Rezoning Petition Review – Charlotte Tree Ordinance

Subject: Urban Forestry Rezoning Petition Review Summary
To: Charlotte Planning, Design & Development
From: Tim Porter, Chief Urban Forester
Timothy.Porter@Charlottenc.gov
 704-622-4829
Rezoning Petition: 2021-112

Date	Description/Status
9/23/2021	UF 2 nd review, Tim Porter

RZ-1: TECHNICAL DATA SHEET

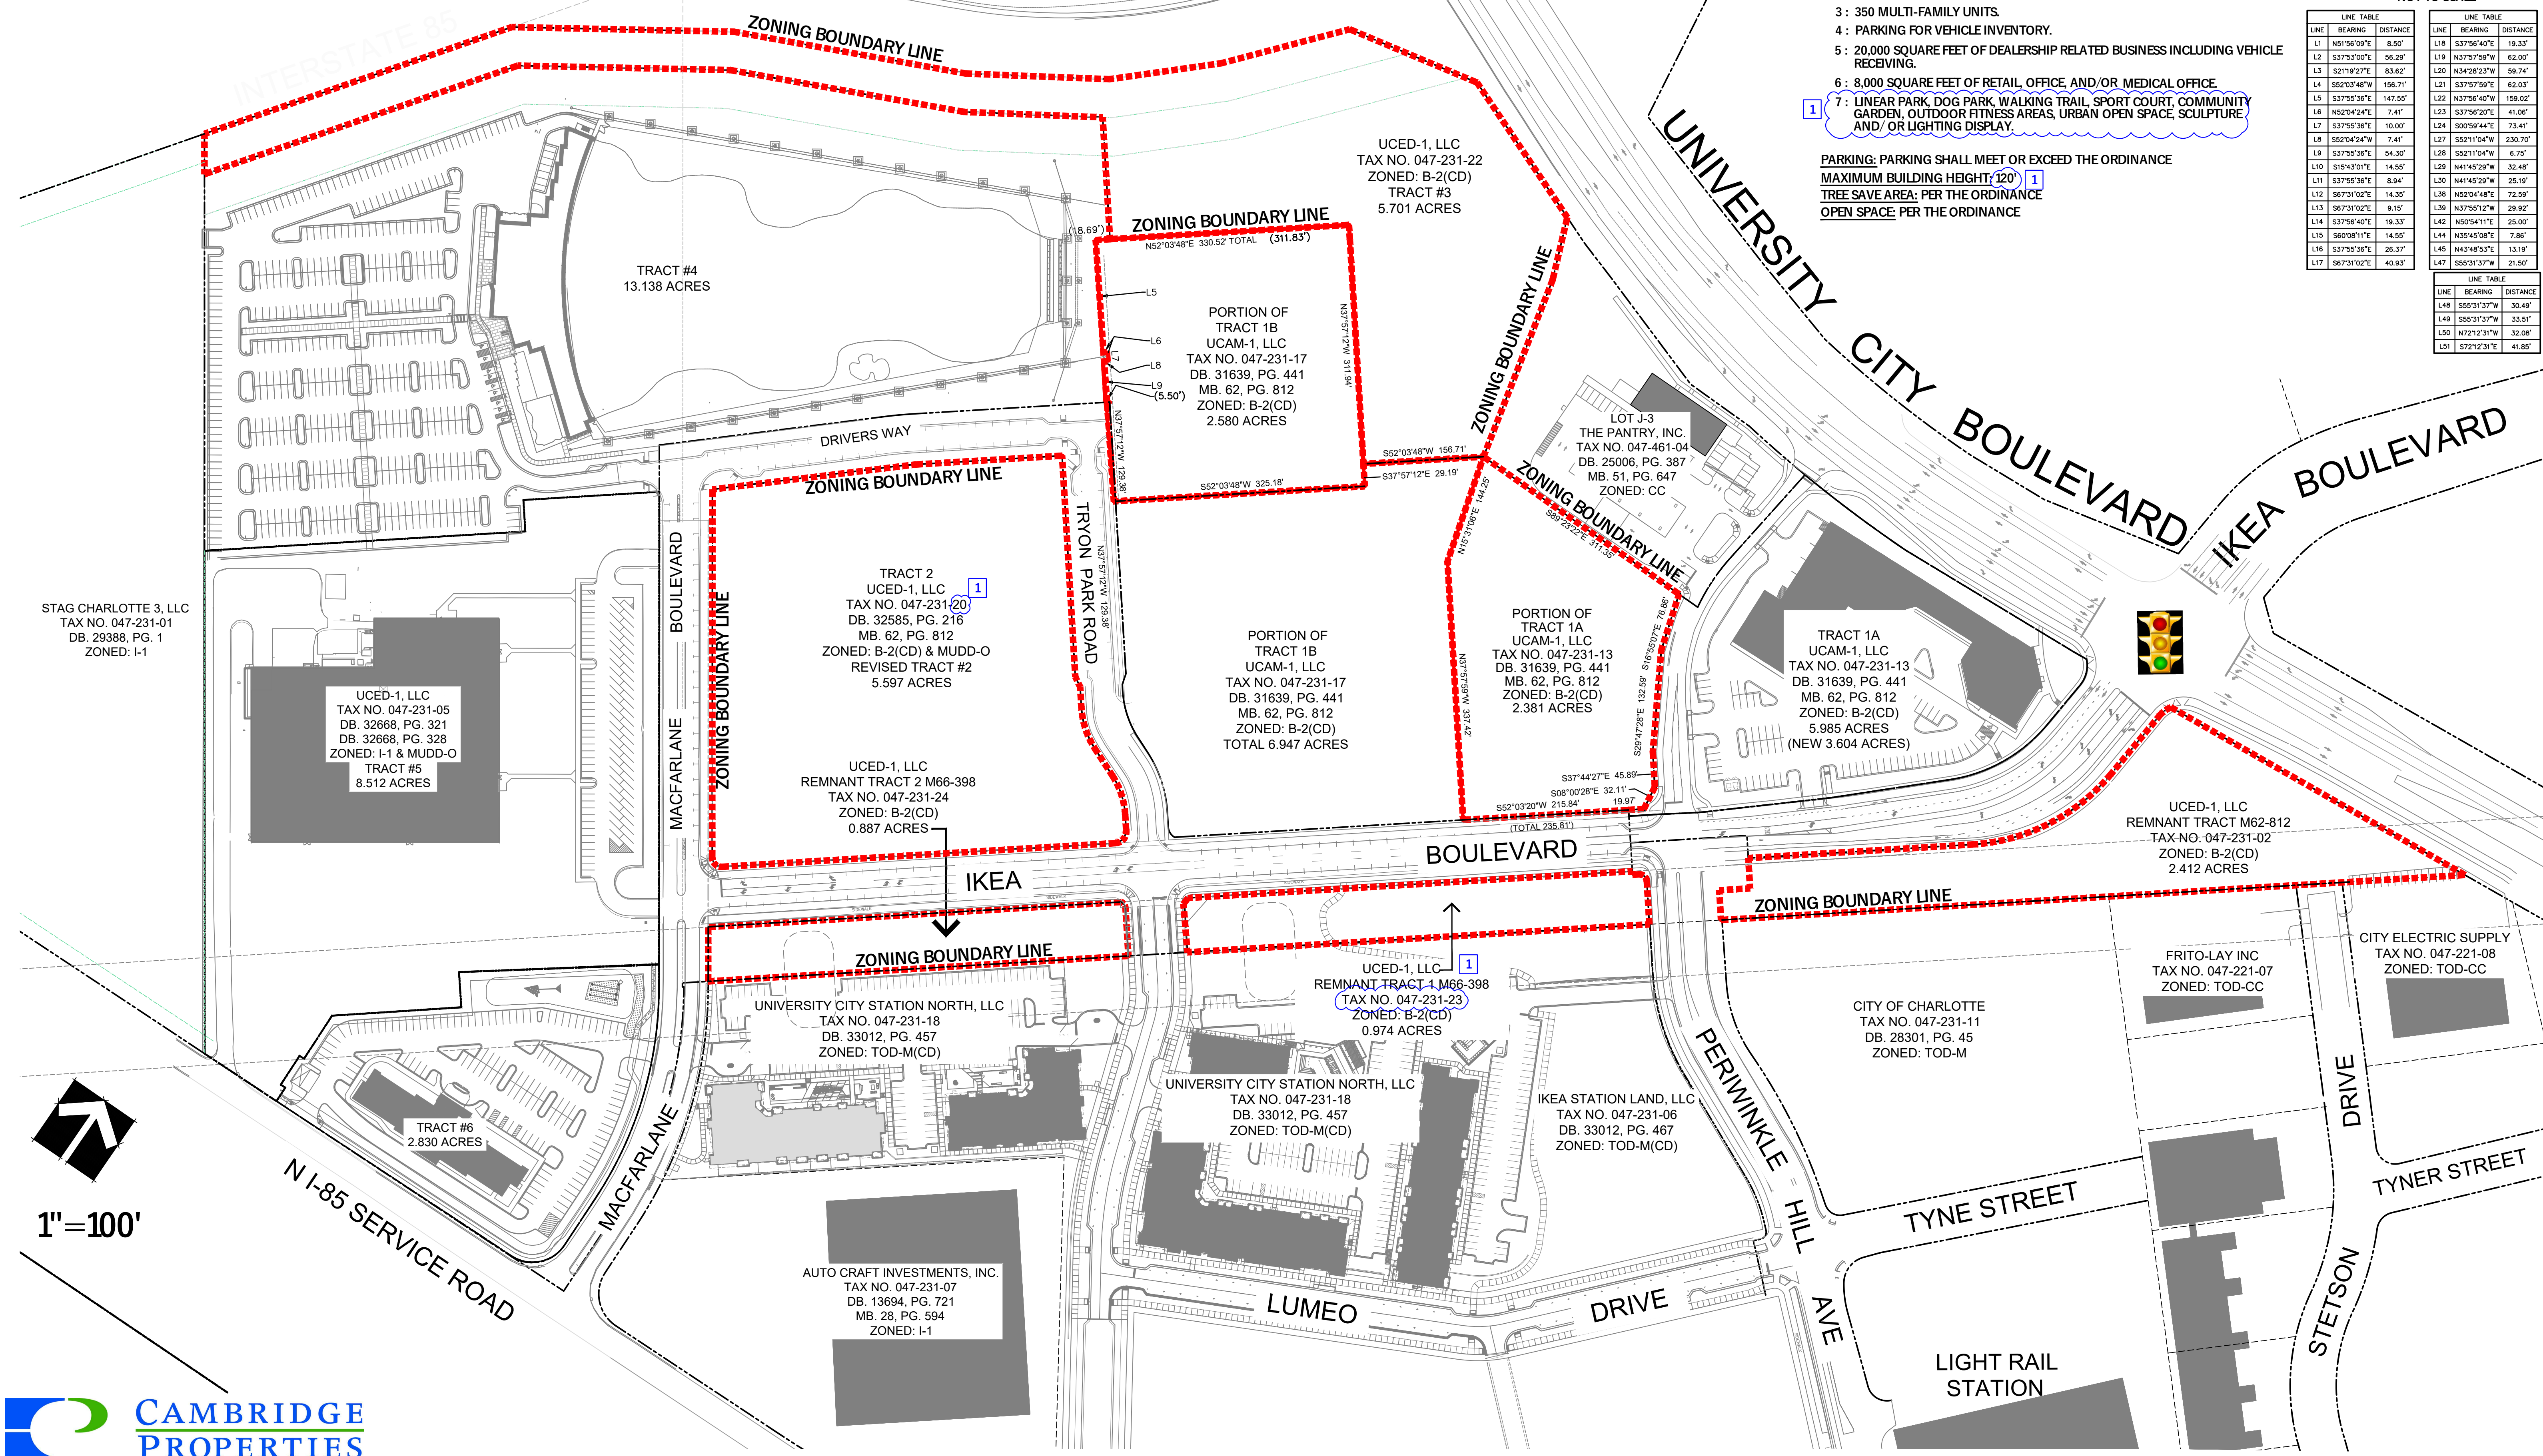
- Submit a tree survey identifying all trees of eight-inch (8) dbh or greater and all planted trees of (2) two-inch caliper or greater and six feet in height that grow partially or wholly within public street right-of-way.
- Include the following note: *“The site will comply with the Charlotte Tree Ordinance”*
